Application No: BE/59/21/PL
Site Address: 339 Chichester Road Bersted PO21 5AN
Description of works: Replacement of blockwork boundary wall with fence and new vehicular access (resubmission of BE/149/21/PL).

Thank you for your internet representation made on 20th May 2021 which has been recorded as an objection with the comments as follows:

SITE PLAN - SHOWING VISIBILITY SPLAYS
1:500 SCALE (at A3)

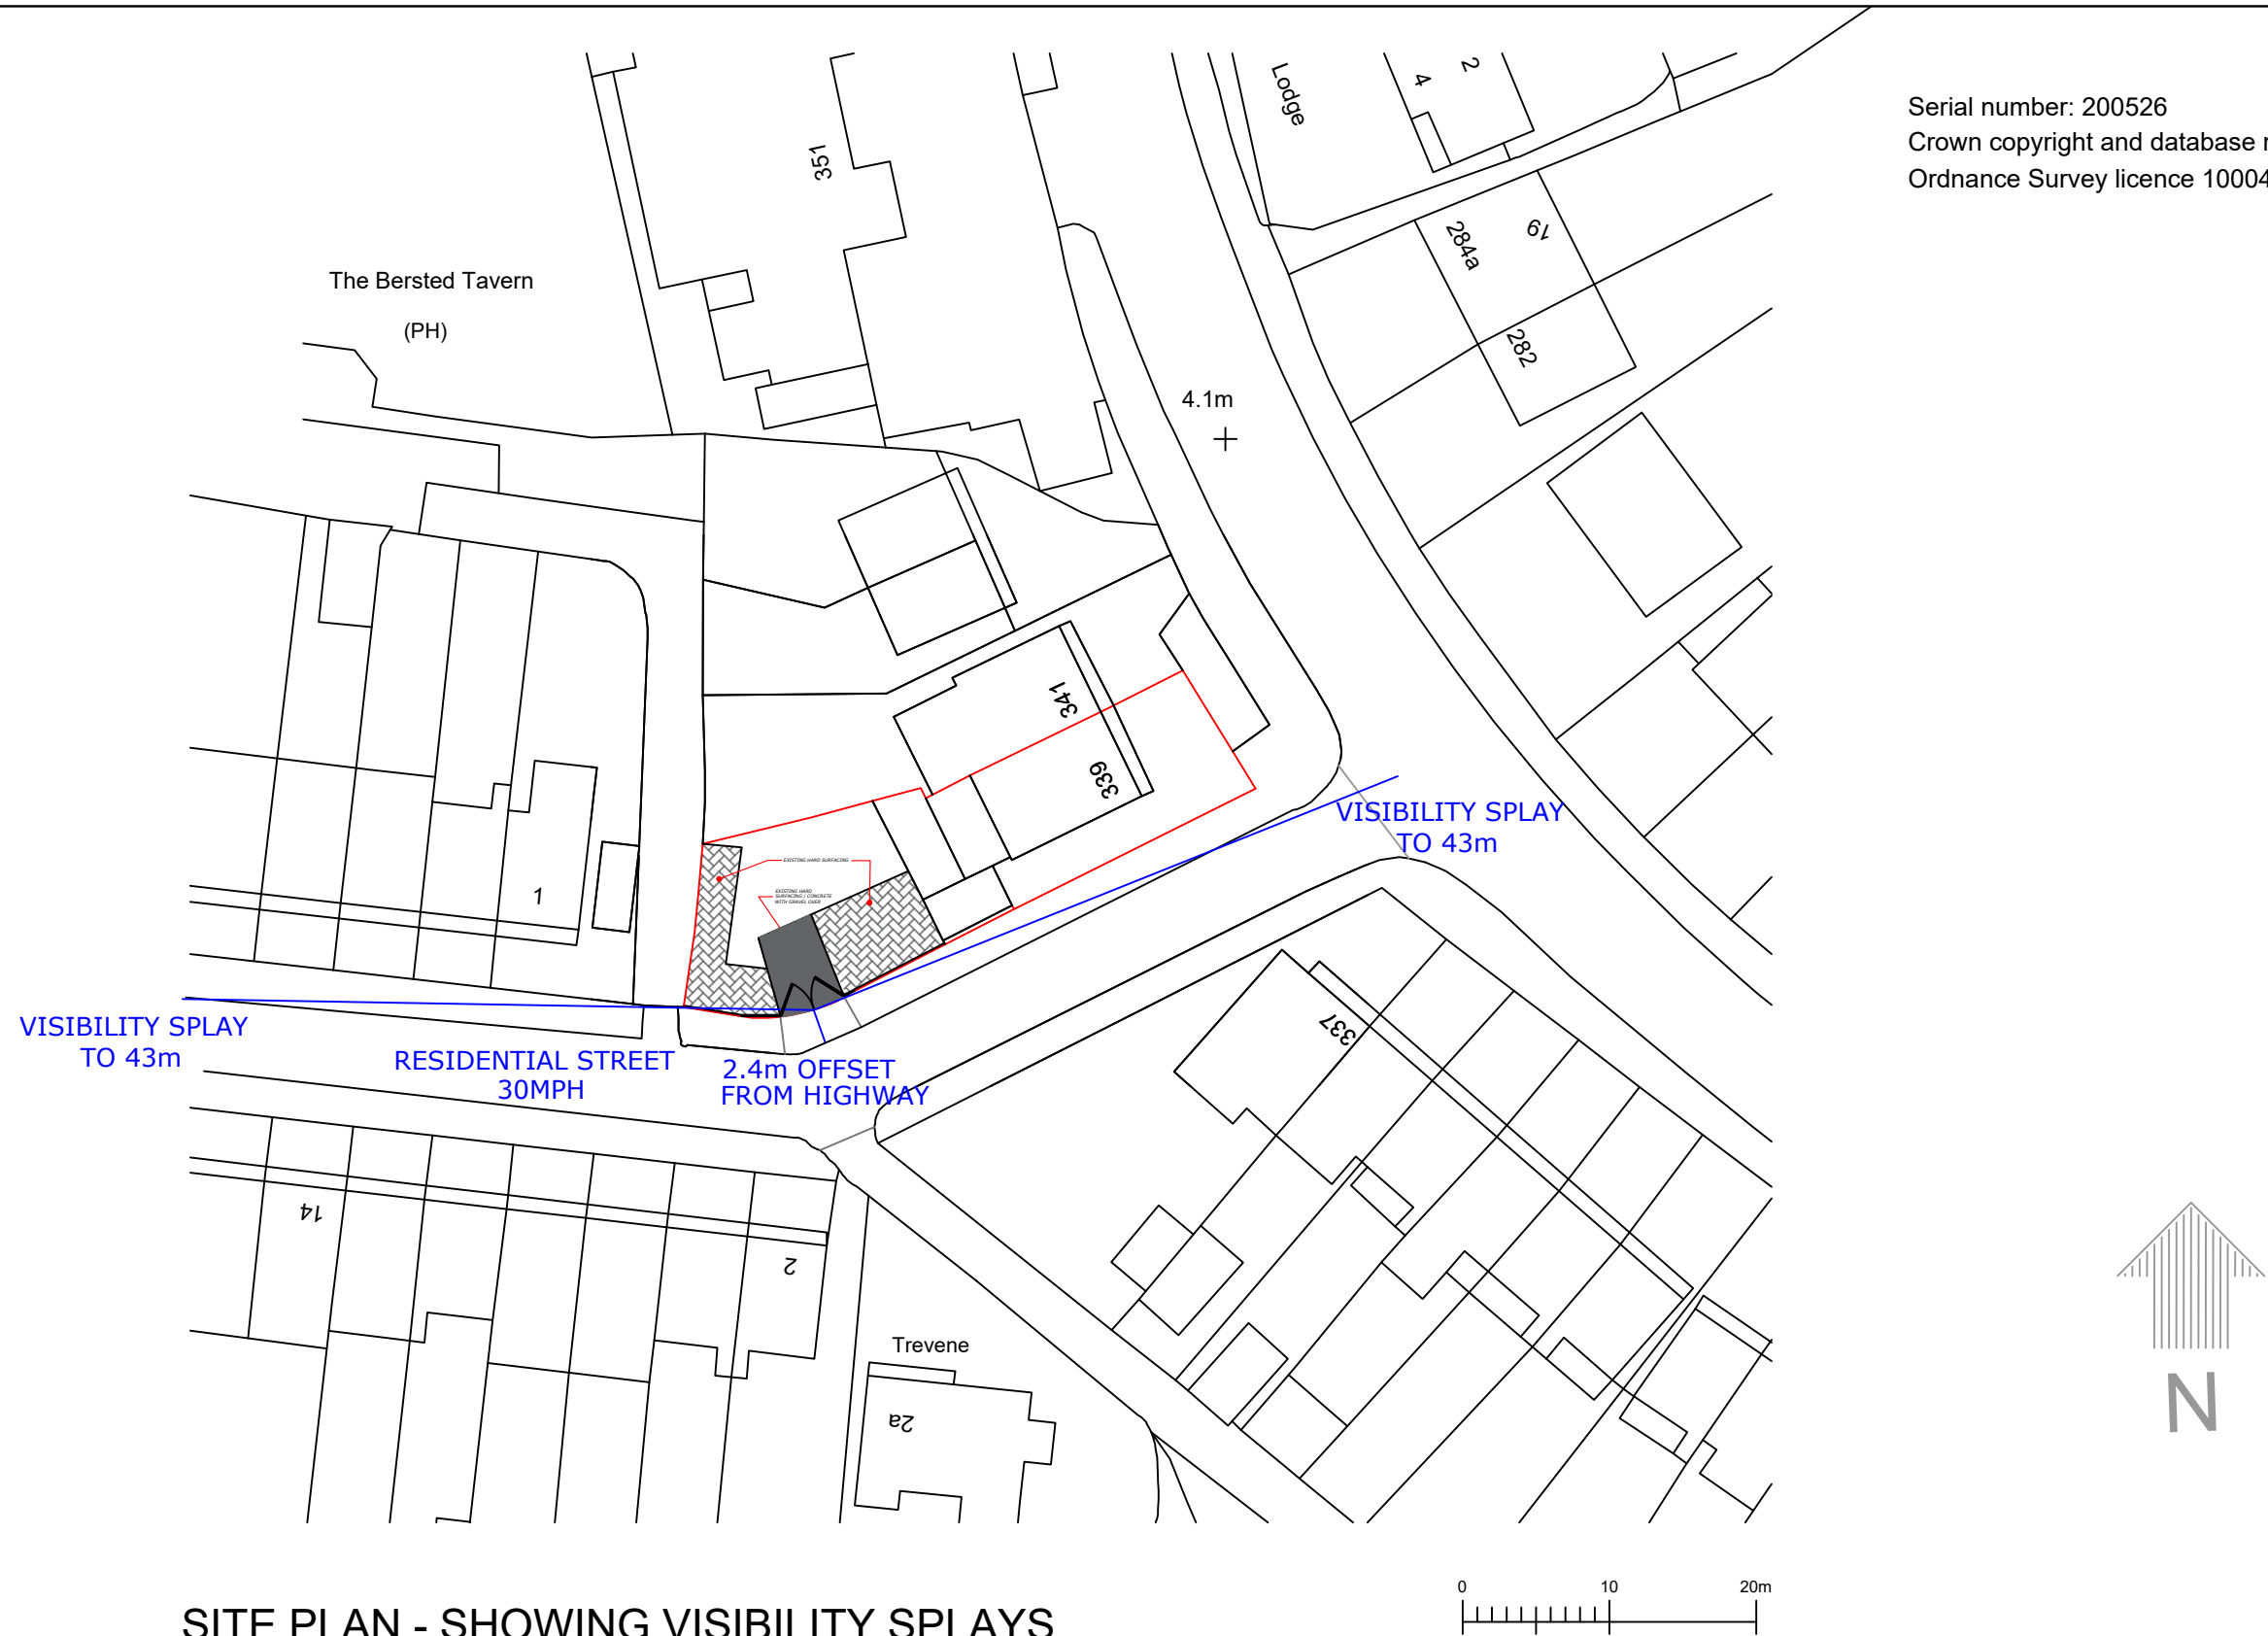
The site plan produced which apparently shows an adequate line of site is false as it does not show the correct location of the dropdown kerb. The actual location will have a restricted view and create great risk to residents and other road users.
